The National Construction Code Volume One

SSDA Submission

Nepean Hospital Redevelopment - Stage 2

Health
Infrastructure

LEVEL 01

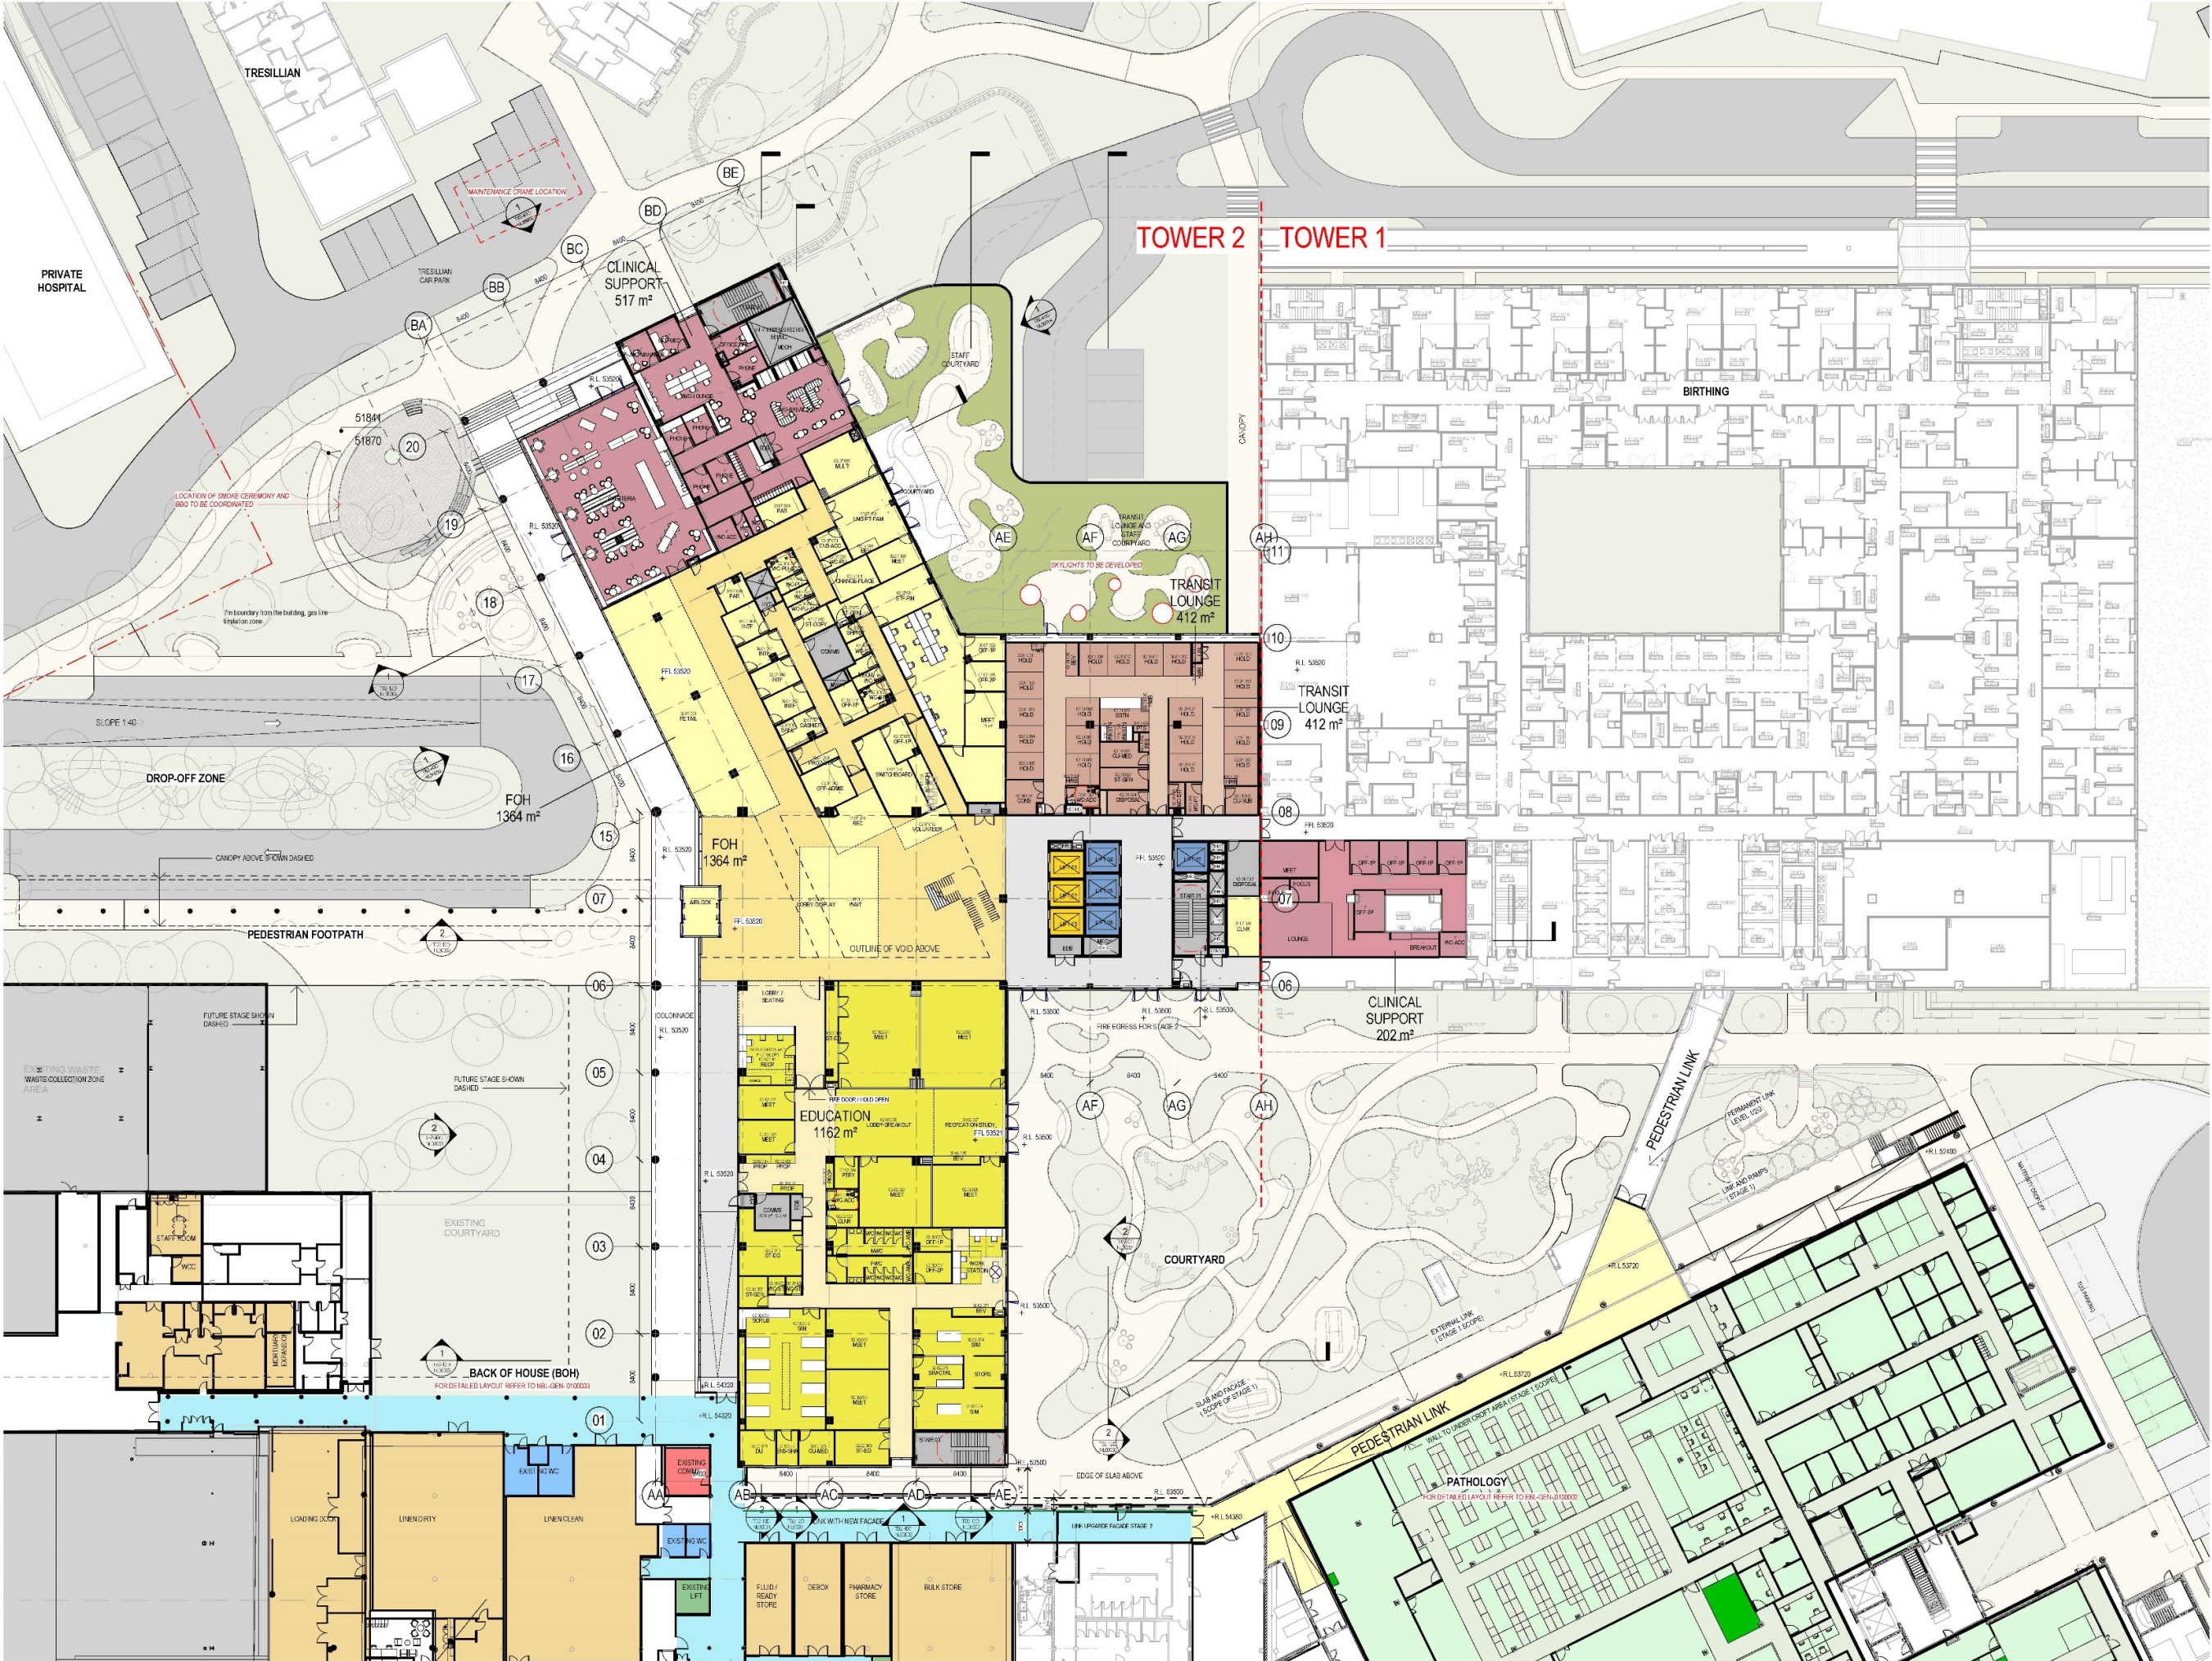
12.	D1.7	<p><i>Fire Stair 01 discharging with the confines of the Building on Level 02</i></p> <p>Fire Stair 01 discharges within the confines of the building on Level 01 to the lobby space in lieu of the stairway discharging directly to open space as required by Clause D1.7.</p> <p>Consistent with the Performance Solution for the two Fire Stairs in the Stage 1 Hospital, the discharge of the fire isolated stairway will be required to assessed as part of the</p>

No.	BCA CLAUSE	DESCRIPTION
		<p>Fire Engineering Assessment to be undertaken by Arup in order to demonstrate compliance with the nominated Performance Requirements of the BCA.</p> <p><i>Fire Stairs 01 & 03 lead to Courtyard which is not directly connected to Open Space</i></p> <p>Once occupants discharge from Fire Stair 01 (via the lobby space) and Fire Stair 03 they discharge into a large courtyard area, however in order to reach open space they will be required to pass through an enclosed linkway connecting the Stage 1 Tower and East Block prior to reaching the internal roadway.</p> <p>Occupants having to pass back within the confines of the linkway is a non-compliance and will be required to be assessed as part of the Fire Engineering Assessment to be undertaken by Arup in order to demonstrate compliance with the nominated Performance Requirements of the BCA.</p> <p><i>Note: The Performance Solution will also be required to address any required exits discharging from the Education space along with the FOH that discharge into the courtyard area.</i></p>
